From: Bruce Taunton <Bruce.Taunton@arun.gov.uk>
Sent: 18 November 2019 17:18
To: Planning.Responses <Planning.Responses@arun.gov.uk>
Subject: RE: Planning Consultation on: A/157/19/PL

NOTIFICATION FROM ARUN DISTRICT COUNCIL
Town & Country Planning Act 1990 (as amended)
Town and Country Planning (Development Management Procedure) (England) Order 2015
Planning Permission
APPLICATION NO: A/157/19/PL

Registered: 1st November 2019
Site Address: Quiet Waters Roundstone Lane Angmering BN16 4AX
Grid Reference: 507454 103377

Description of Works: Variation of condition 3 imposed under A/81/18/RES relating to pedestrian access link between Quiet Waters site & the CALA Homes Cresswell Park Development to the north.

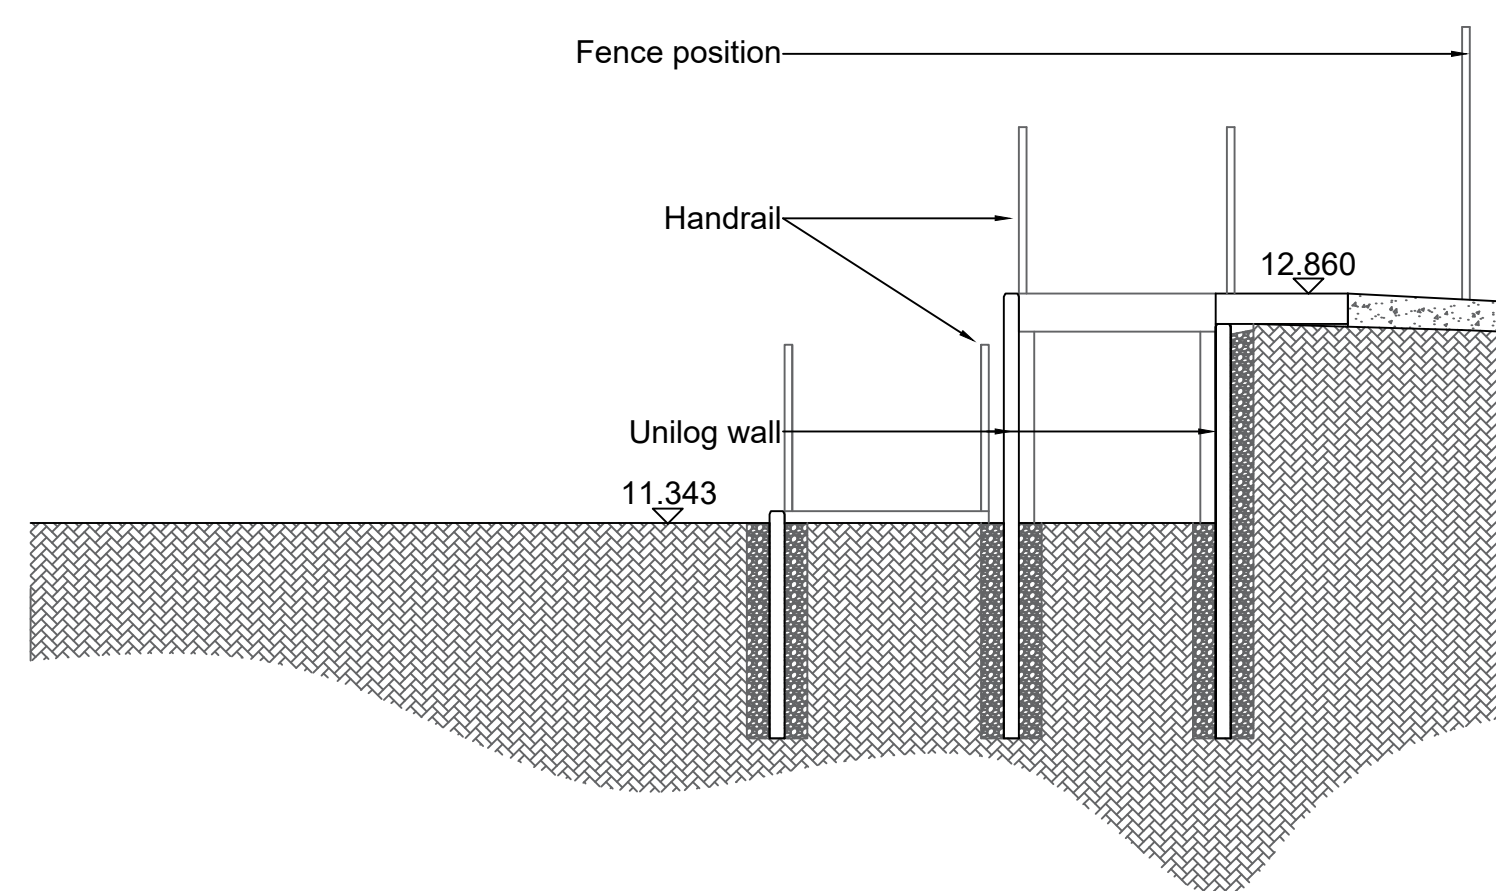
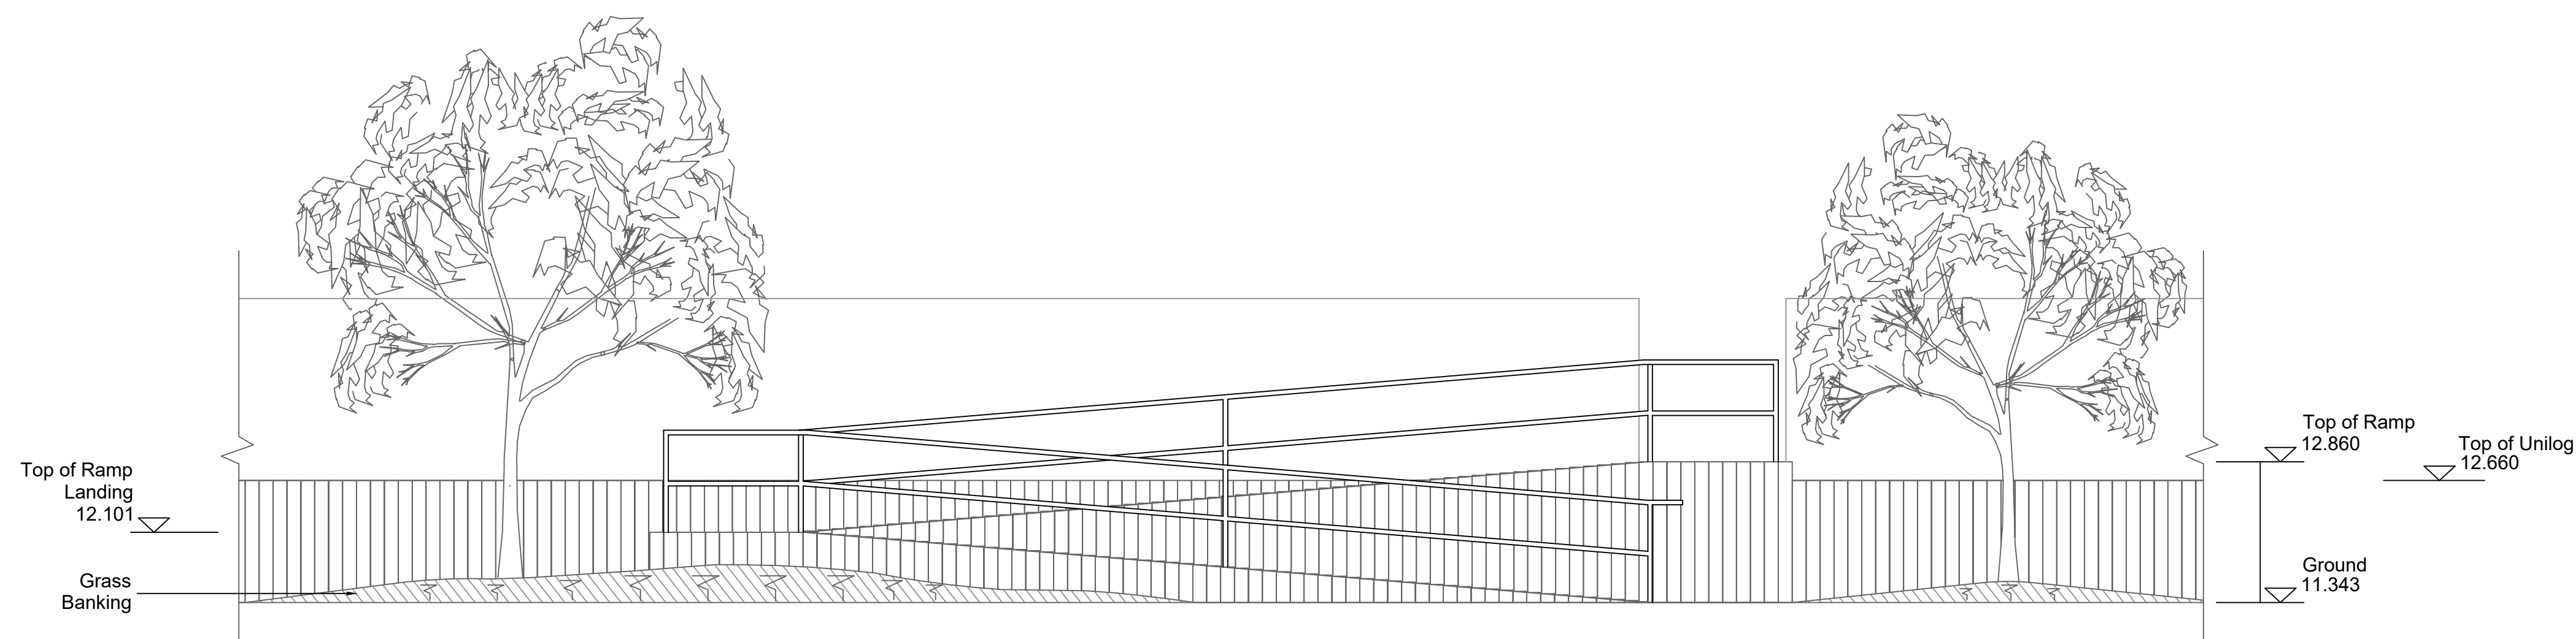
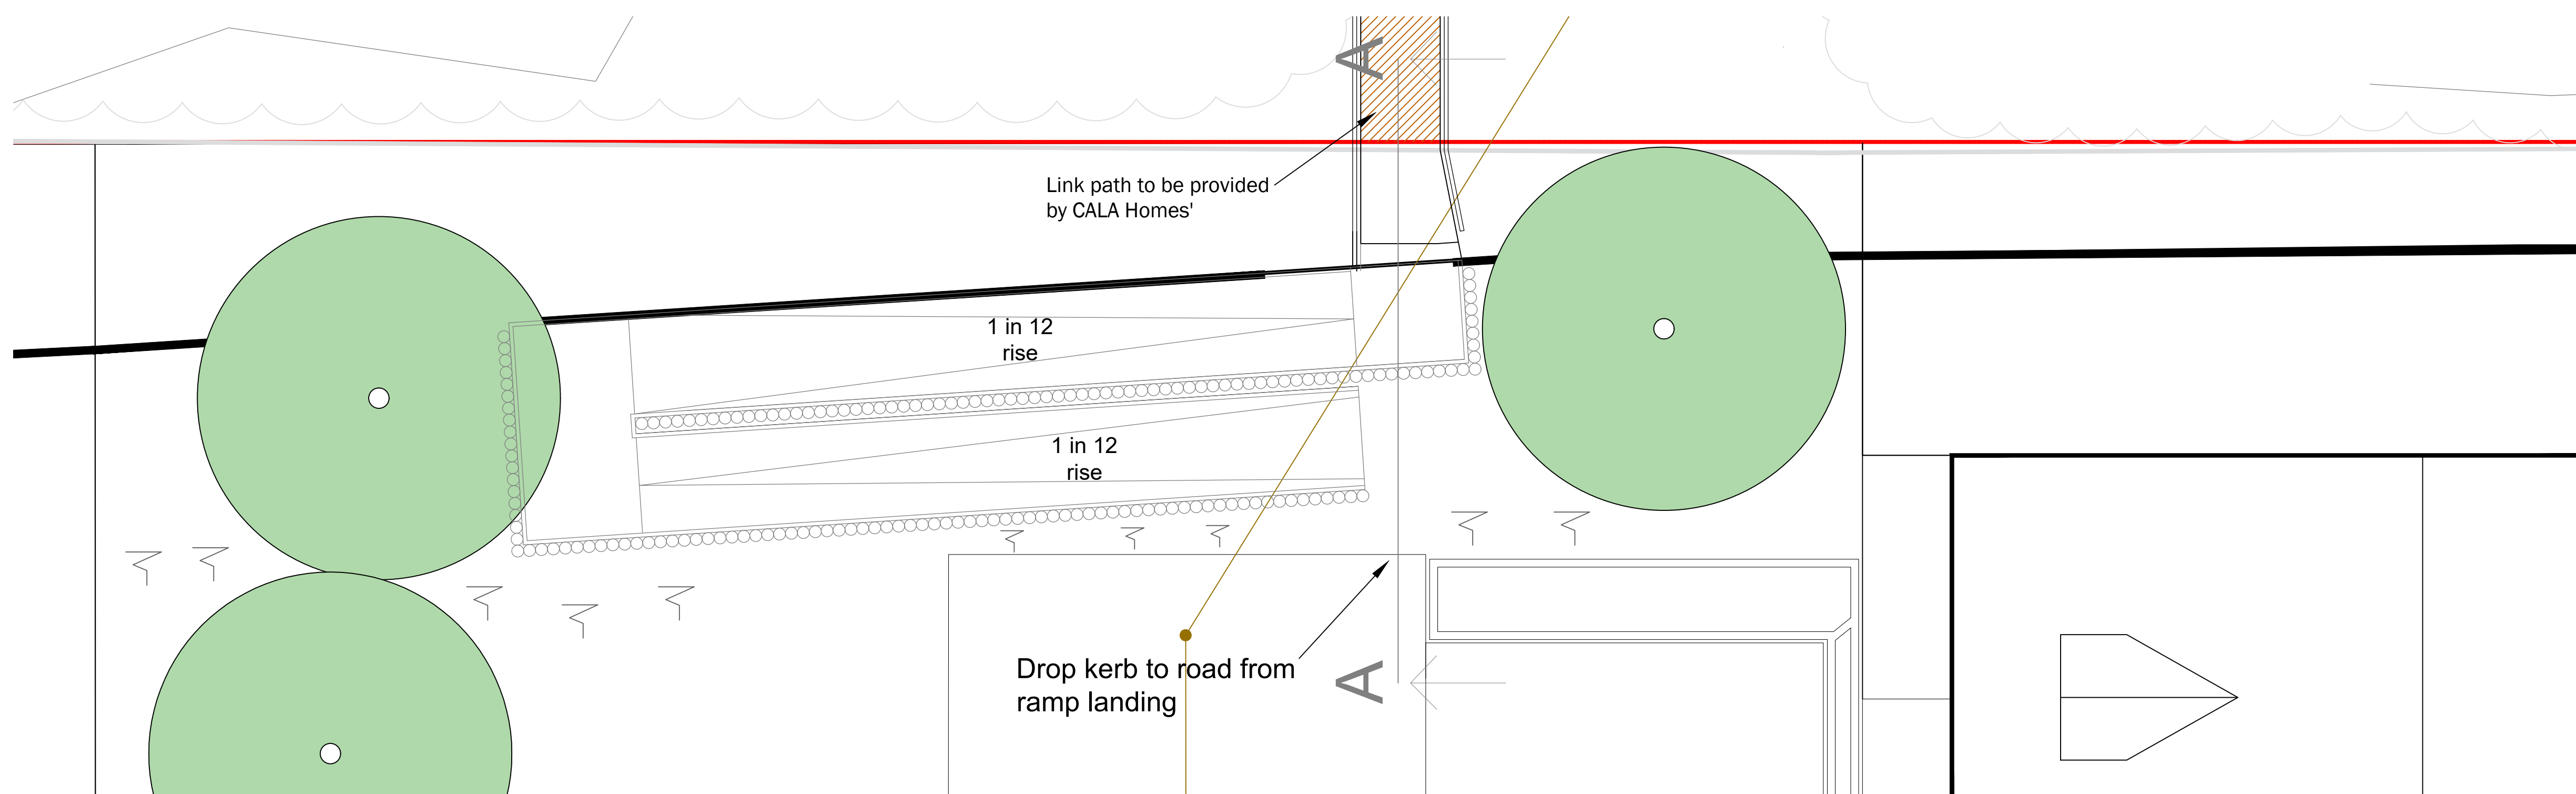
According to manufacturers details the unilog retaining wall may be structurally adequate but only has a design life of 25 years, is this considered appropriate for a public pedestrian footway and who will be responsible for the medium to long term maintenance of the wall and ramp?
